Your ref:	27 Graham Terrace	<b>Please reply to:</b>	<b>Phoebe Graham</b>
Our ref:	21/00834/FULL	Tel No:	07971 024216
		Fee Queries:	0207 641 6500;
		Email:	planningreception@westminster.gov.uk;
Kate Meredith Hardy Residence One (London) Ltd 126 New Kings Road Uncommon London SW6 4LZ United Kingdom		<b>Incomplete Applications</b> Development Planning City of Westminster PO Box 732 Redhill, RH1 9FL	
		16 February 2021

**Address: 27 Graham Terrace, London, SW1W 8JE**

**Proposal: Erection of rear ground floor infill extension with new link to lower ground floor, extension of existing first floor rear wing with new window openings, installation of double glazed windows, installation of air condenser unit in rear garden, refurbishment of front and rear facades.**

Thank you for your application received on 11 February 2021. I am writing to inform you that your application is incomplete for the following reason(s):

project no.	drawing no.	rev
5007	(PL)102	A
drawing	PROPOSED ELEVATIONS	scale
		1:50 @ A1 1:100 @ A3
		date
		20.11.20
		drawn
		WB
project	27 Graham Terrace	checked
	London, SW1W 8JE	printed
client	Longfield

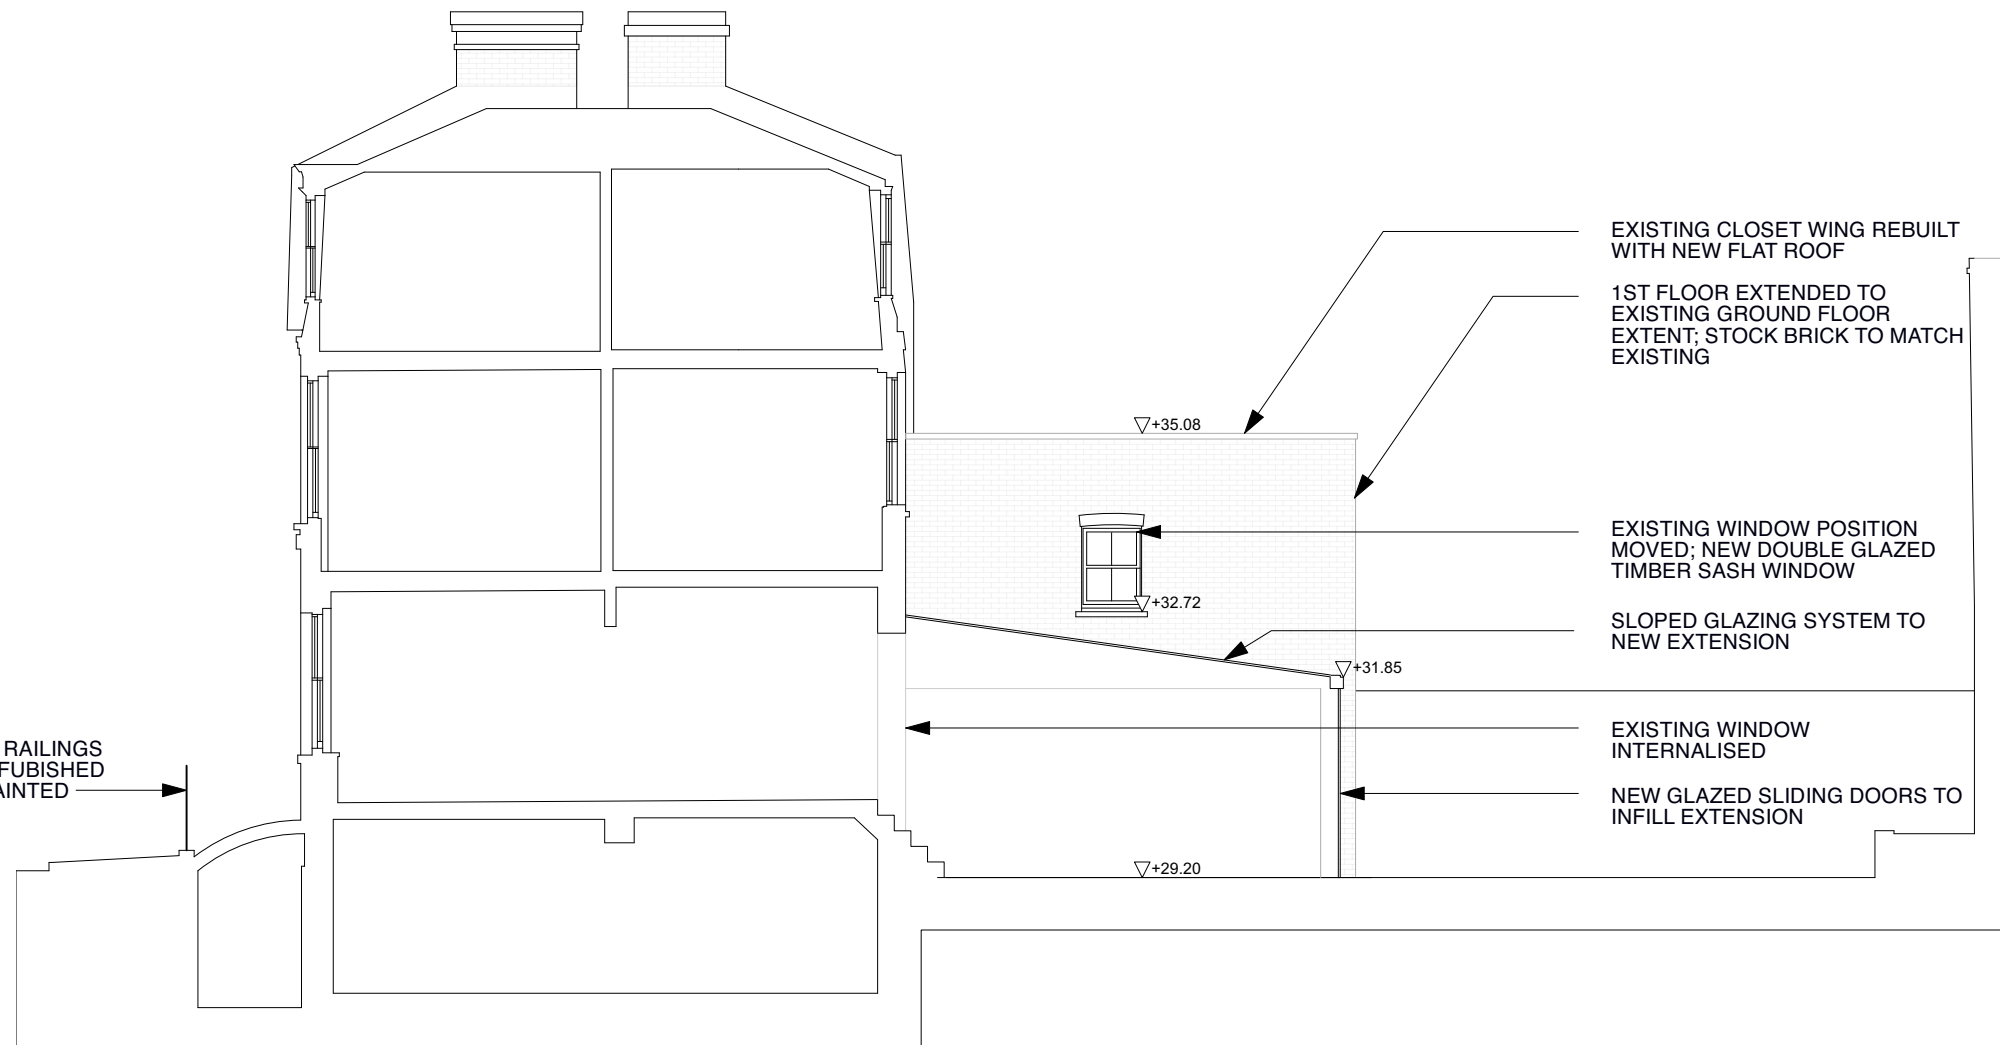
- 2 Please confirm which windows are proposed to be replaced. The proposed drawings show the ground and first floor windows to the front and rear elevations but the design and access statement also shows the second floor front windows.

Please amend either the drawings or the design and access statement so it is clear what is proposed.
